Application No: R/160/20/HH
Site Address: 17 Sea Avenue Rustington BN16 2DQ
Description of works: Proposed two storey rear extensions and various roof alterations.

Thank you for your internet representation made on 27th September 2020 which has been recorded as an objection with the comments as follows:

PROPOSED EAST ELEVATION 1:50

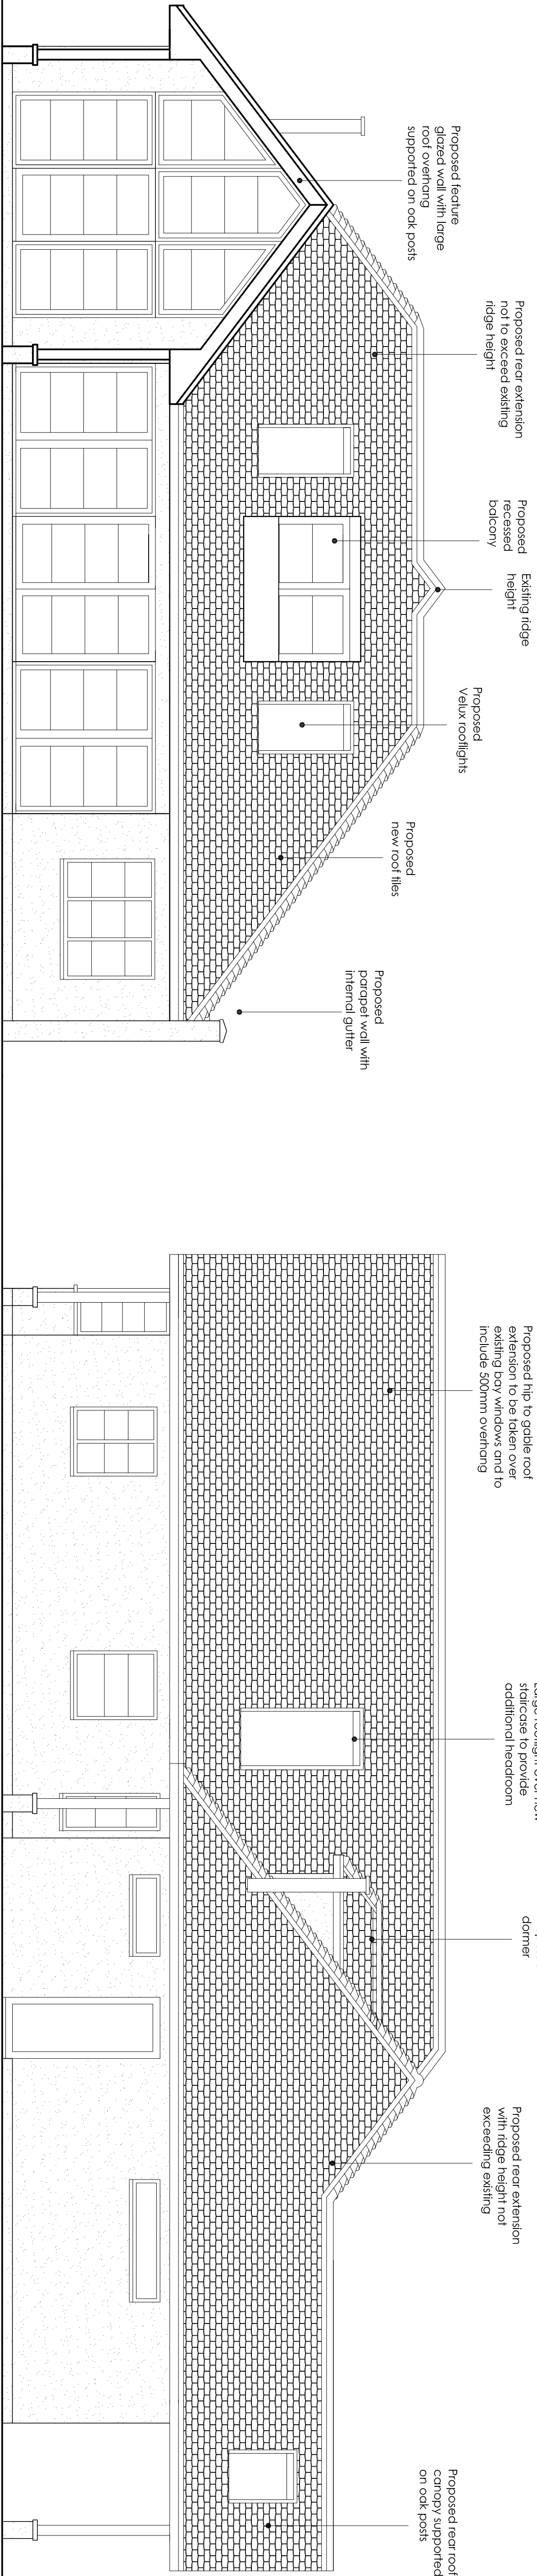
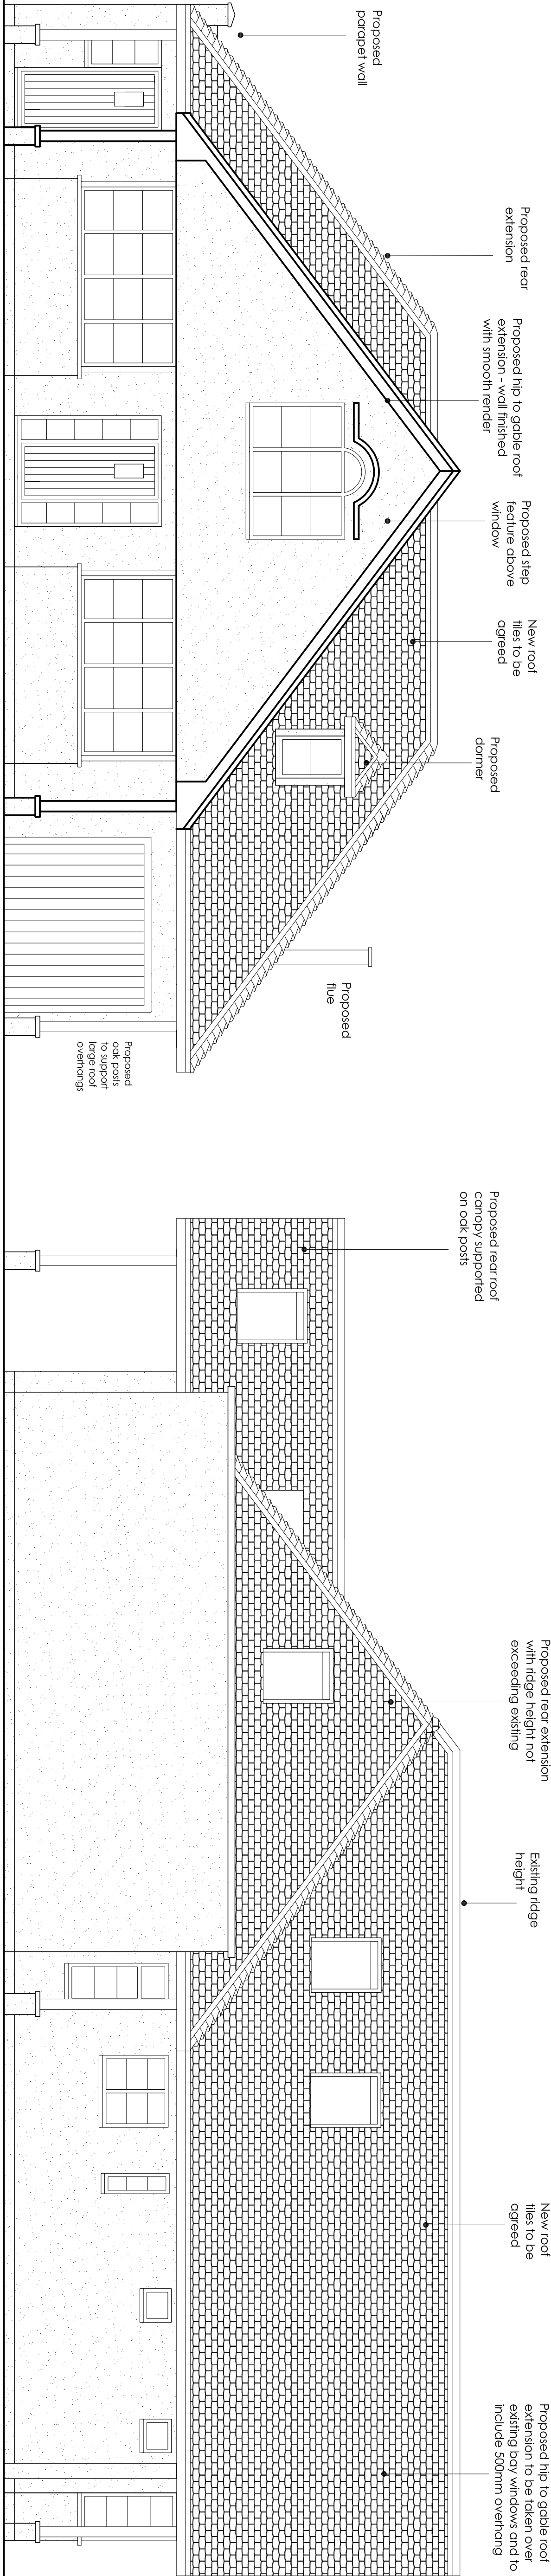
- 2) The proposed hip to gable roof extension will obstruct light to the south facing windows of 15 Sea Avenue particularly during winter months when the sun is lower and could potentially block aerial reception to this property. It would also appear that the proposed roof line would also project beyond the existing one.

PROPOSED EAST ELEVATION 1:100

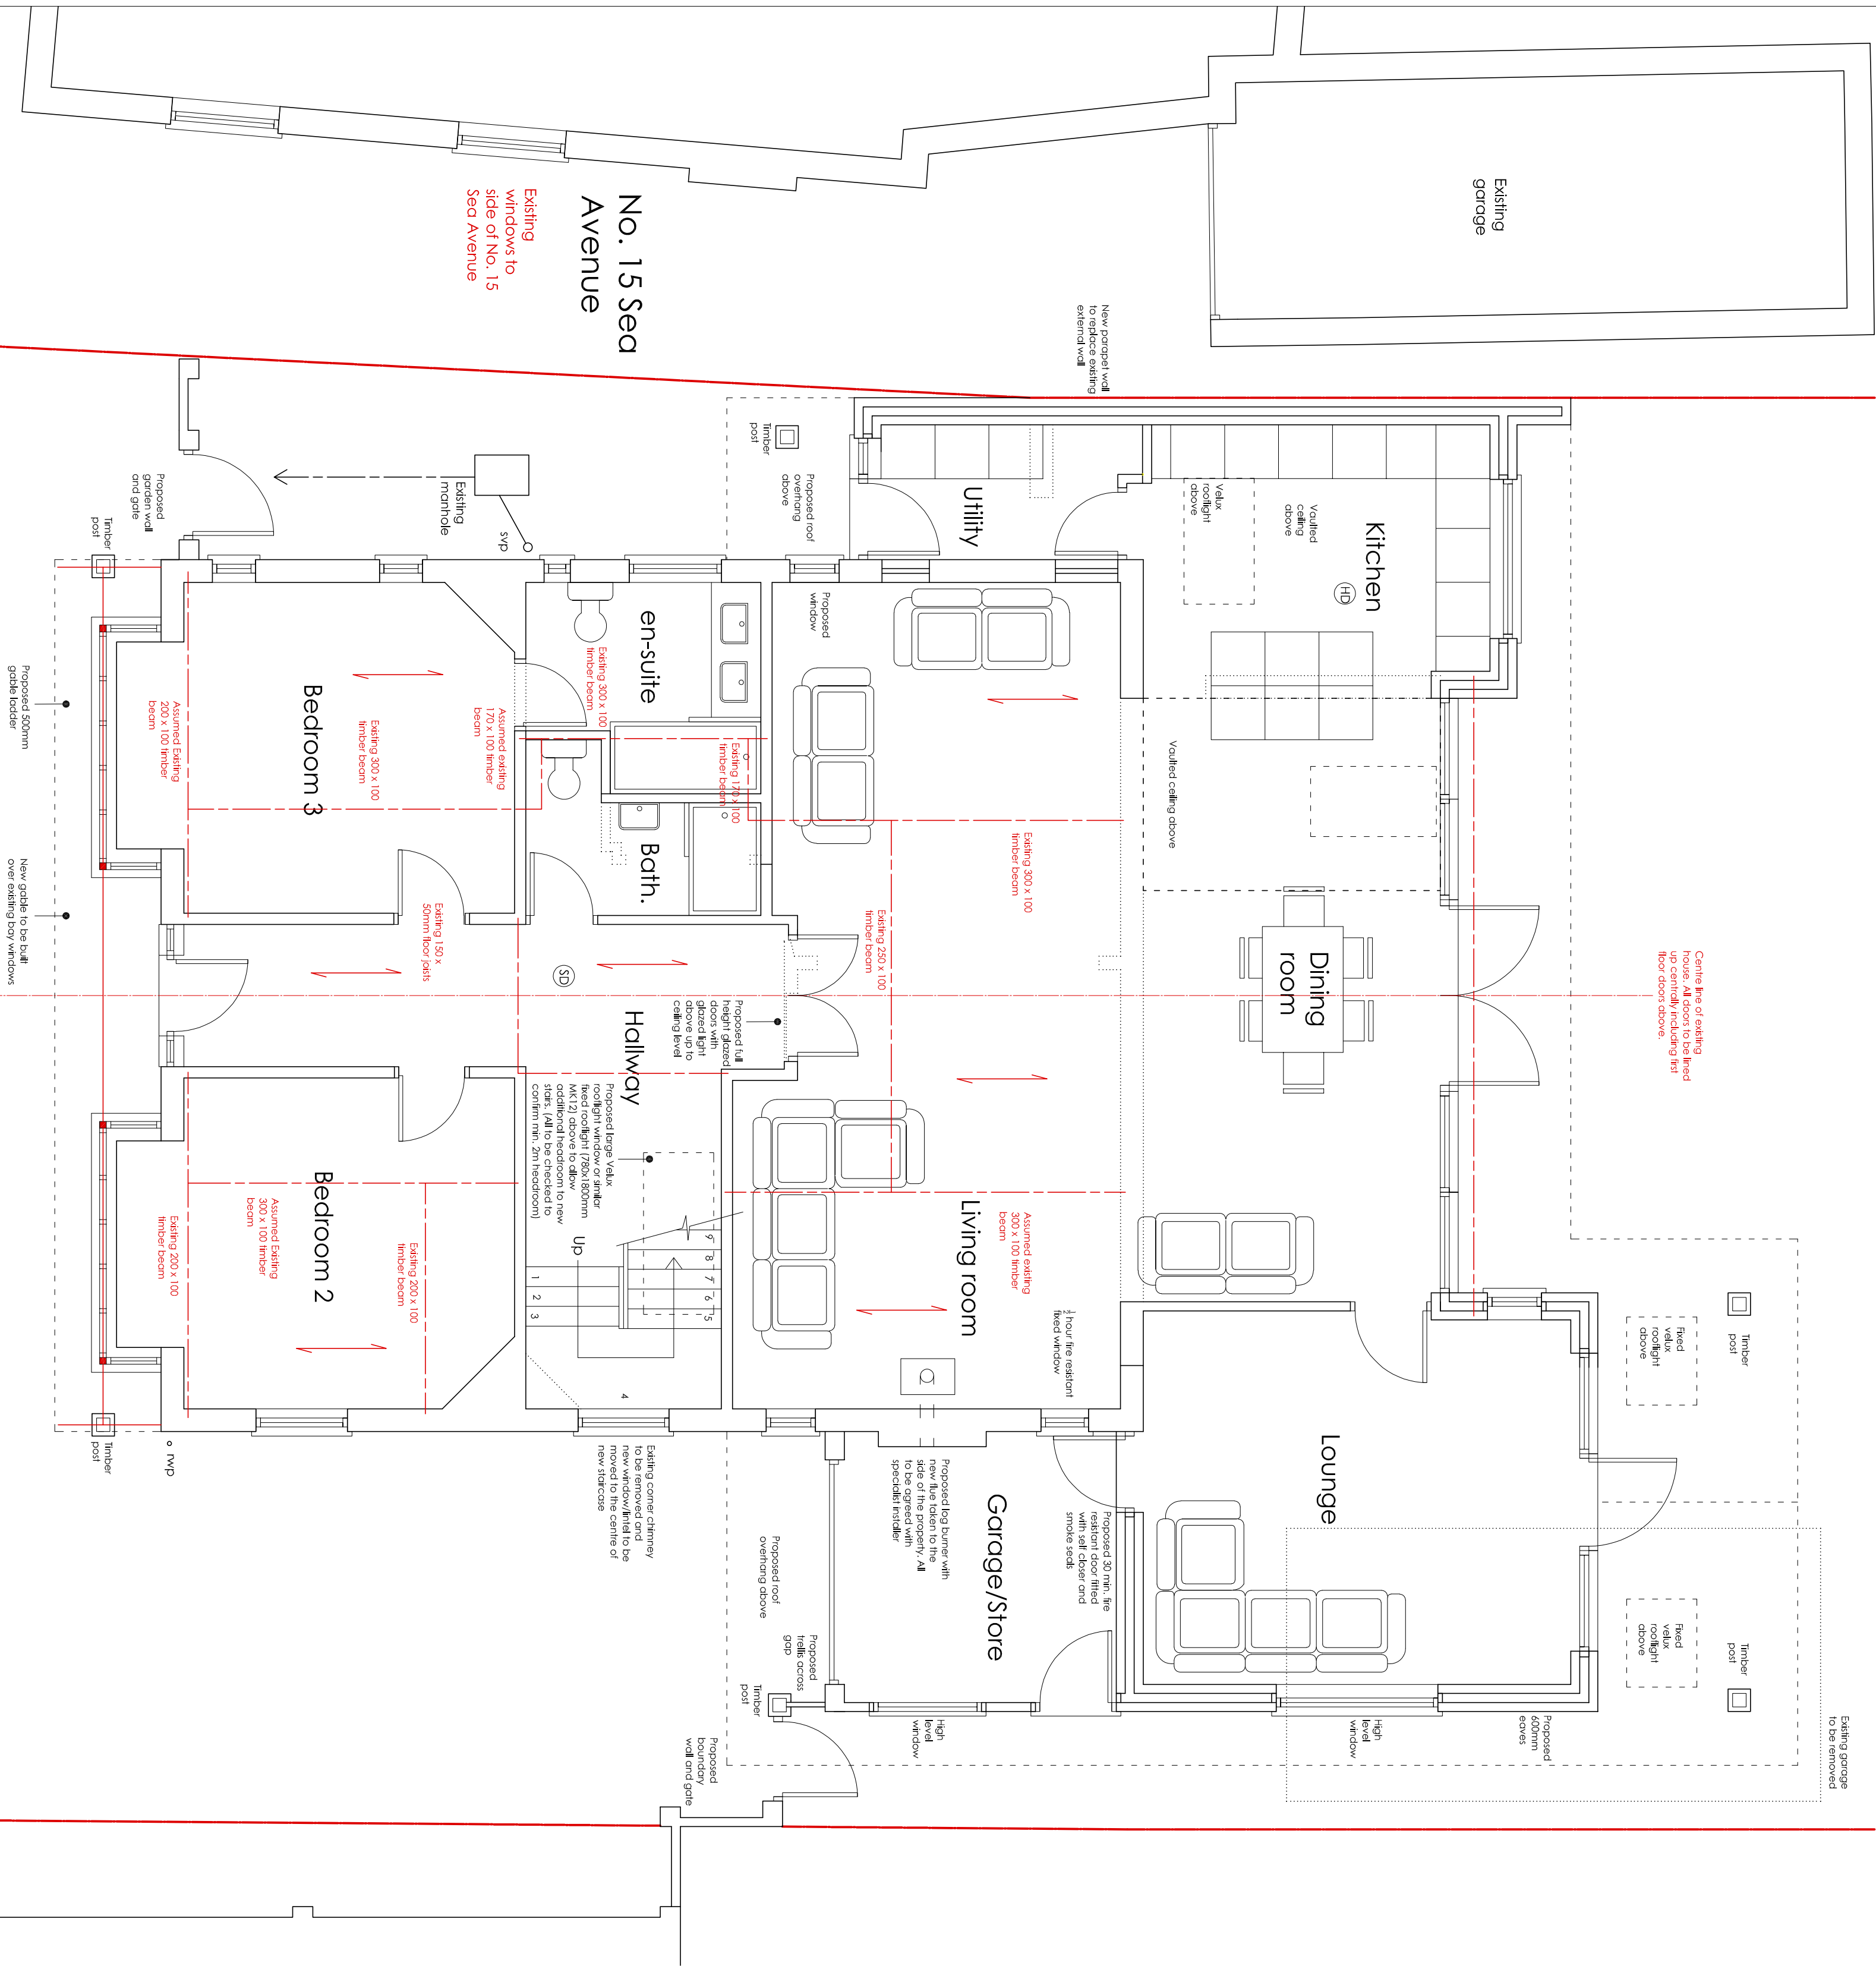
- 1) The proposed 1st floor balcony with double french doors and Velux roof lights on the east elevation will overlook a large area of the rear garden belonging to 15 Sea Avenue infringing on its current seclusion and privacy, this being a major change from the existing small opaque roof light.

PROPOSED NORTH ELEVATION 1:100

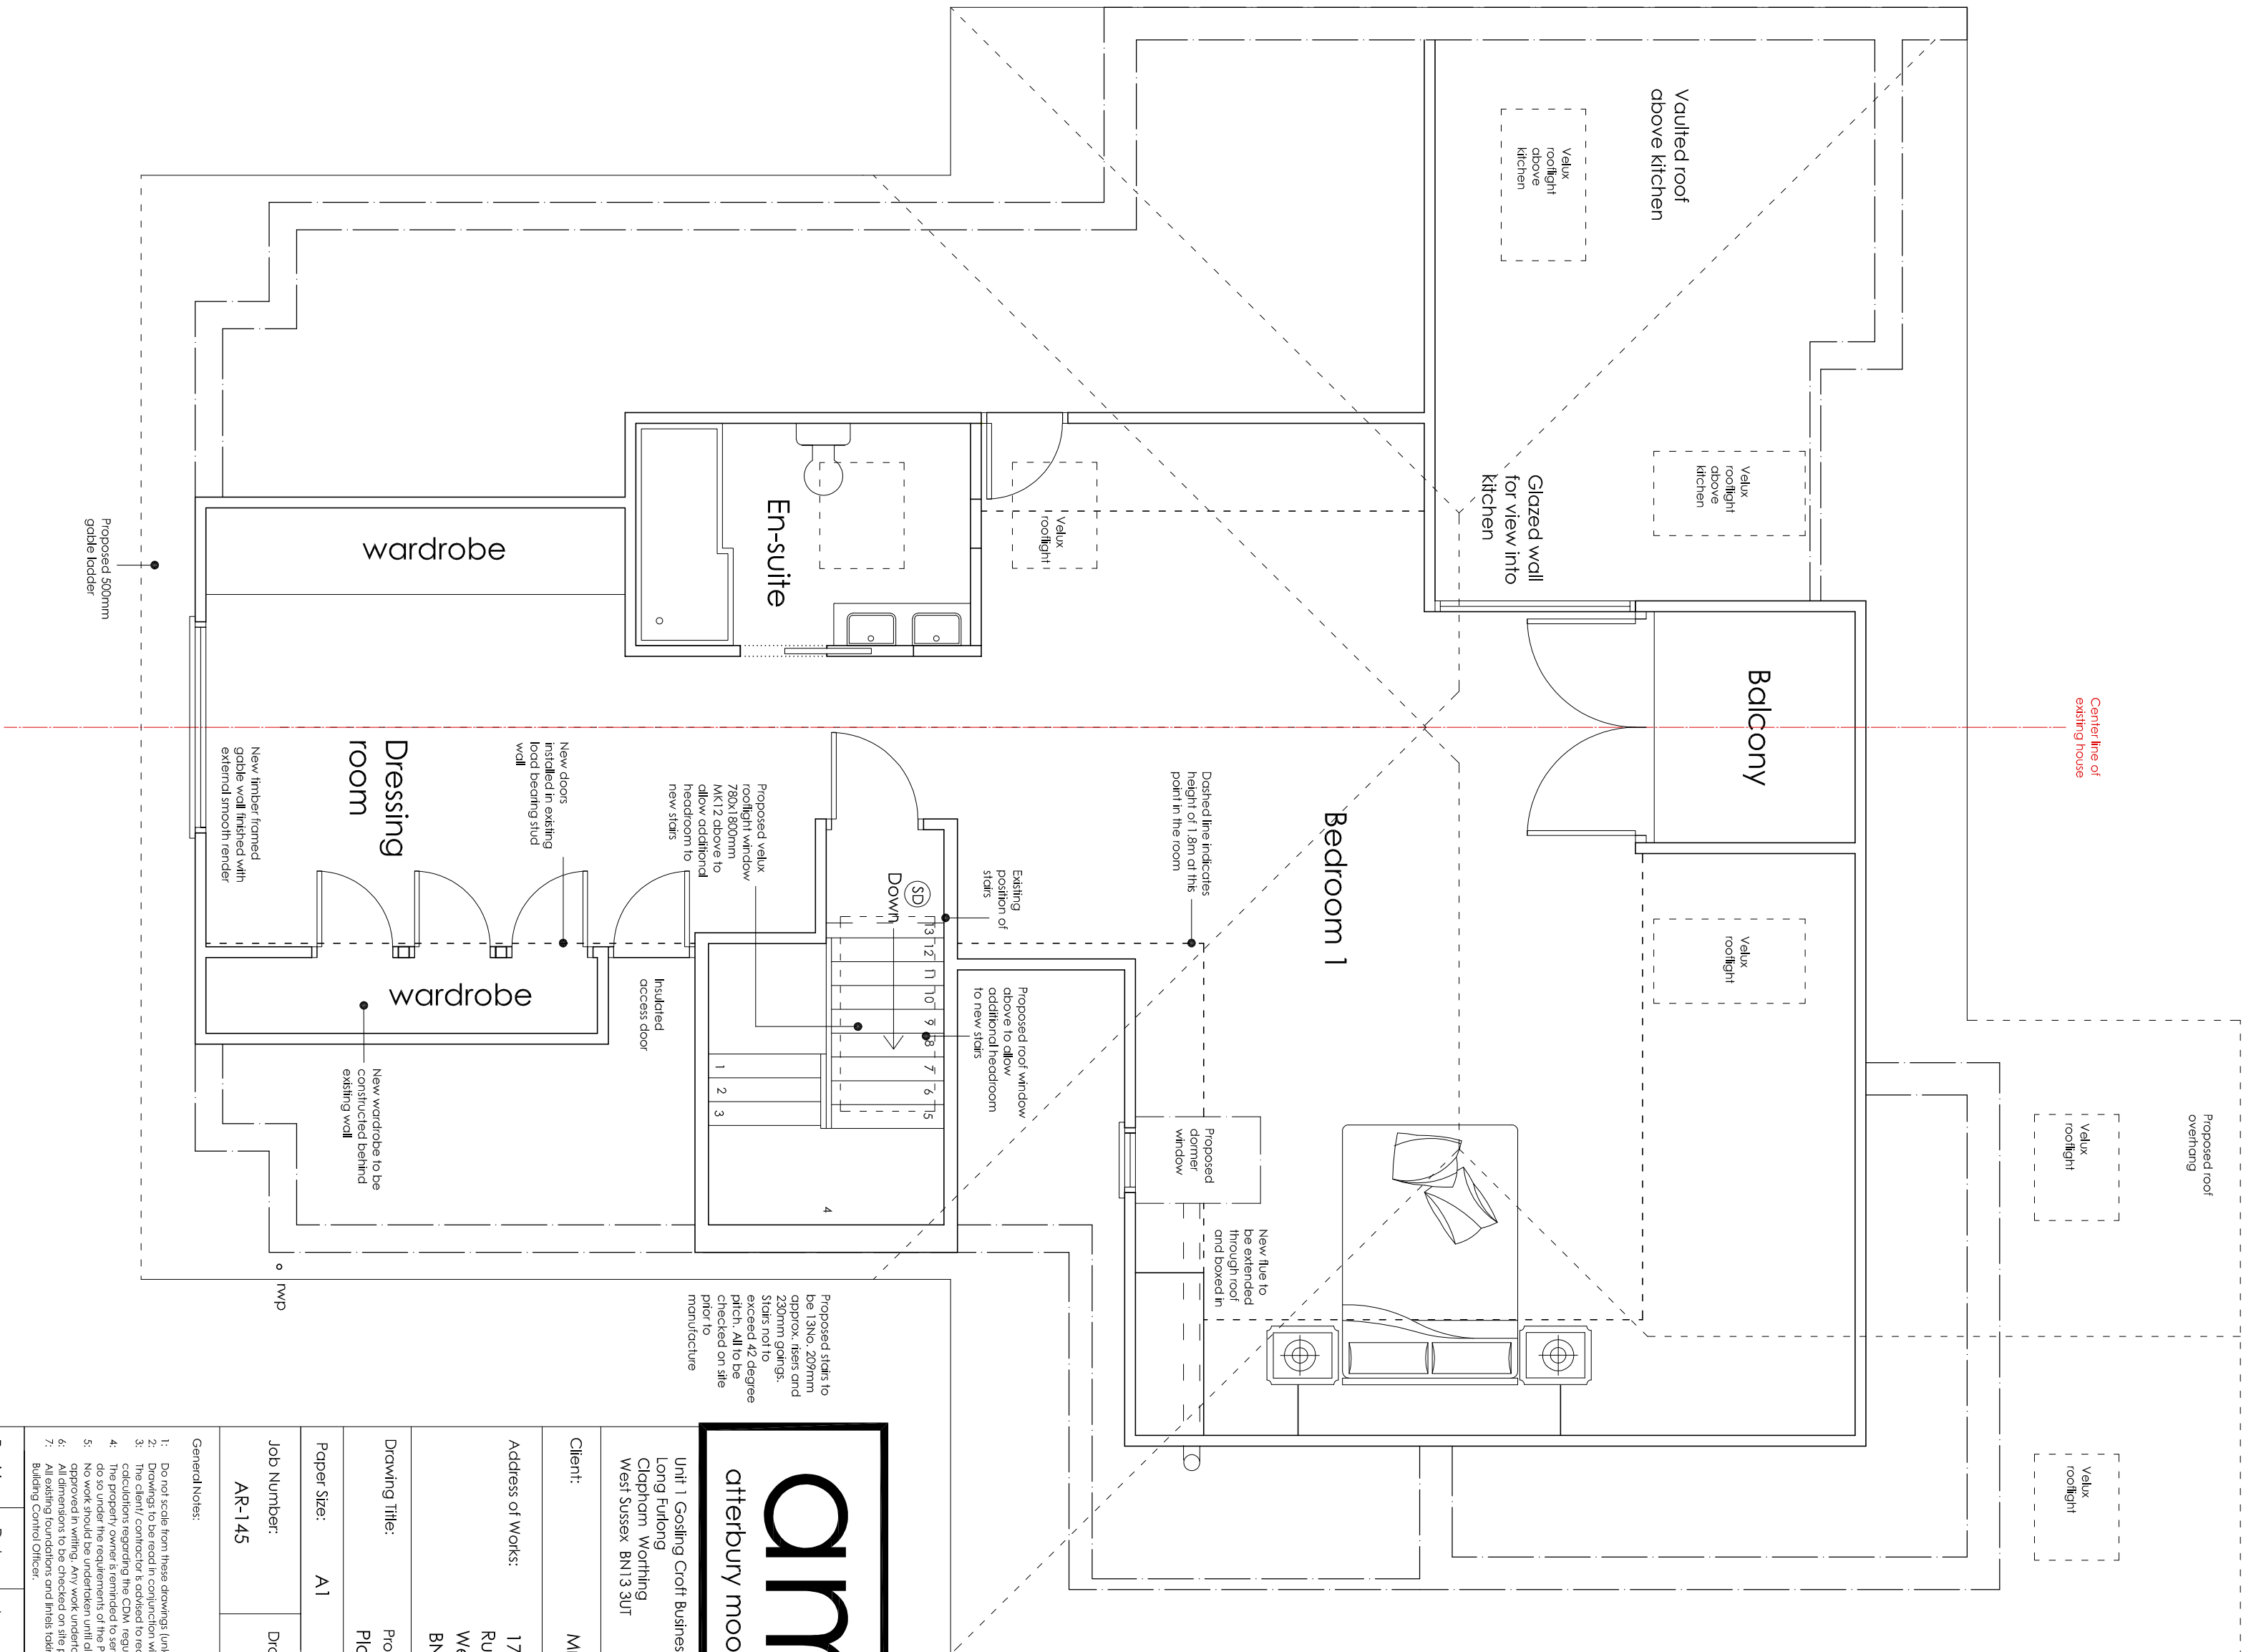
- 3) The existing lean to on the north elevation is set back from the boundary line. The replacement of the lean to by the proposed building works would further breach the boundary line. It is believed that responsibility for the boundary lies with 15 Sea Avenue.

- 4) The new parapet wall on the north elevation seems excessively high and will appear unsightly. Currently the two south facing lounge windows either side of the chimney breast have been decommissioned, however, should these be reinstated, they would face the proposed parapet wall. In addition, it will visually narrow the access to the garage of 15 Sea Avenue and potentially affect the property value.
